**From:** [Steve Chamberlain](#)  
**To:** [A30 Chiverton to Carland Cross](#)  
**Subject:** Matters relating to Compulsory Purchase at Nancarrow for deadline 3  
**Date:** 24 April 2019 22:40:09

The matters which we would to submit in relation to land potentially impacted by CPO are as follows;

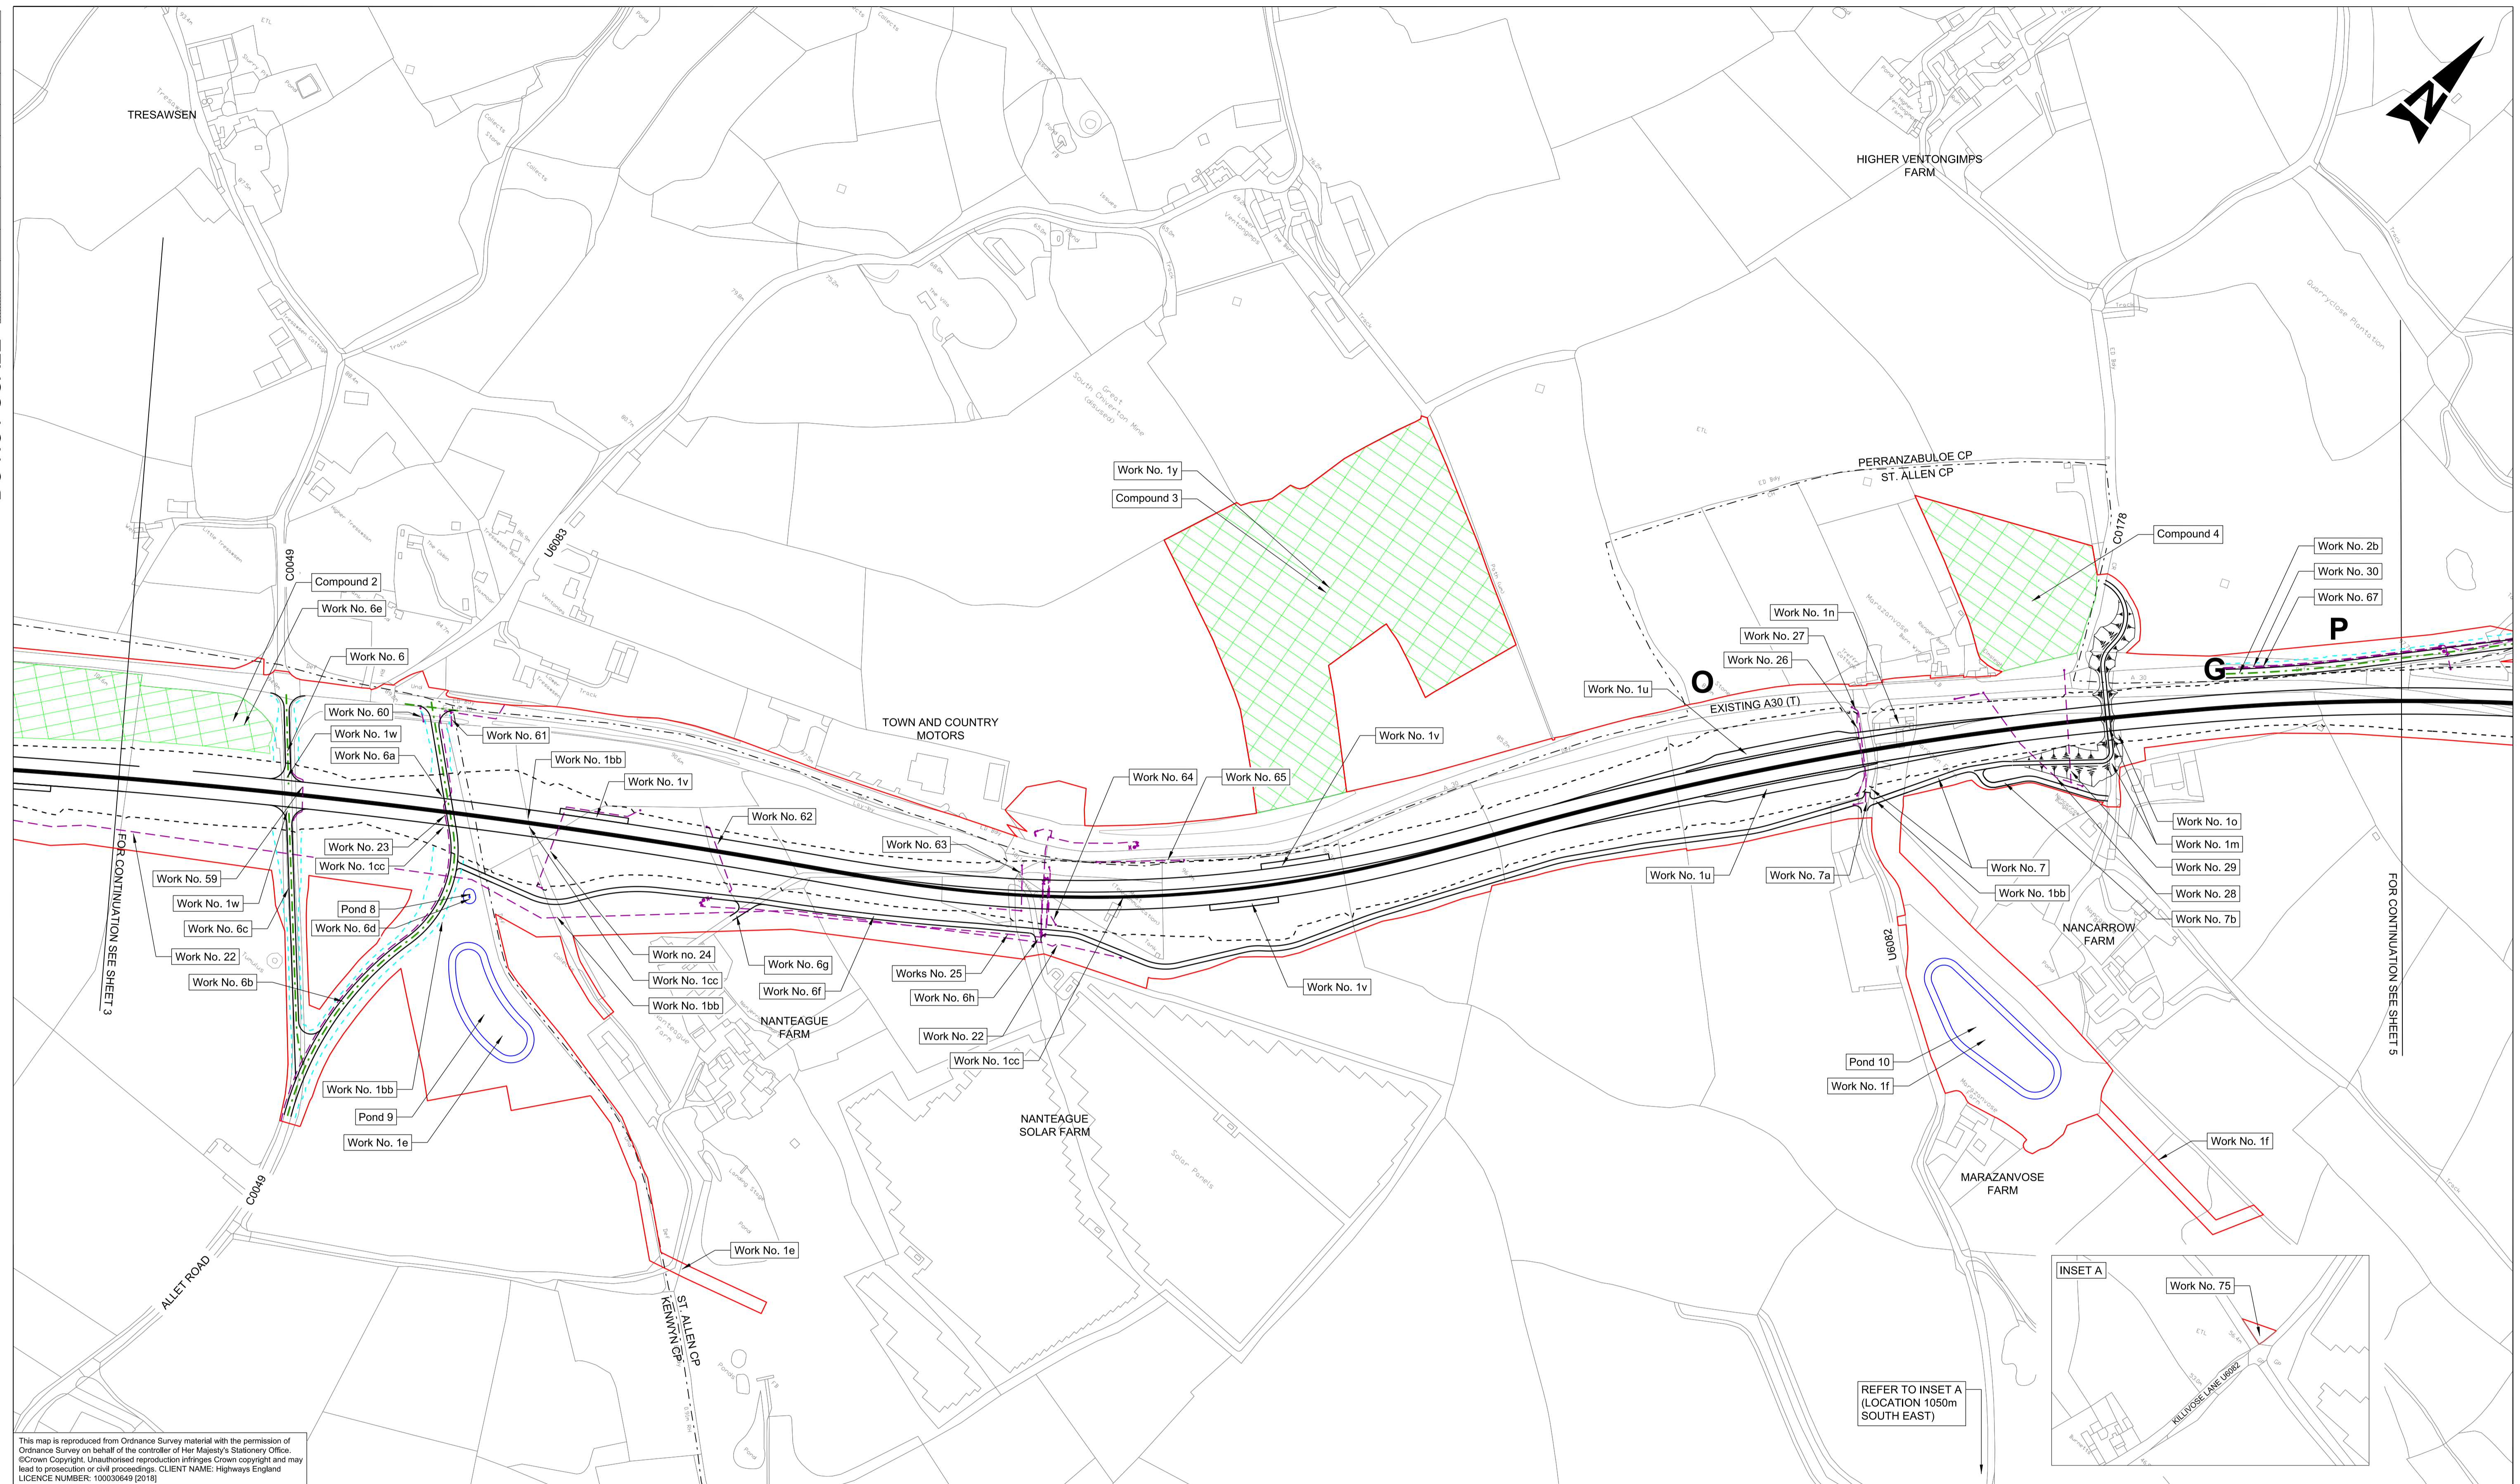
1. Field know as 'Three Corners', West of St Freda, through which a new section of

road for local traffic is planned. On Highways England works plan, this area contains Pond 11; work number 30, 31, 28; Work number 1q, 2c, 2e and 8b; work number 66 and 32.

- Pond 11 seems to have been sited on a considerable incline. Would it be better to site this further down into the unused part of the field (to the east) which is lower (more suited to drainage) and which would leave a larger area above as a useful field for Nancarrow agriculture. Alternatively, Nancarrow could retain the whole area around and below the pond wherever it is sited.
- To the North of the new minor road, there are two triangular areas, one not under a Compulsory Acquisition and the other, is proposed for landscape planting. We object to having the second area taken unnecessarily out of our holding. If it was kept by us it would be, when added to the other retained land, usefully productive land for Nancarrow. Gate and hedge/fencing accommodation would be understood as provided by Highways England to all fields.
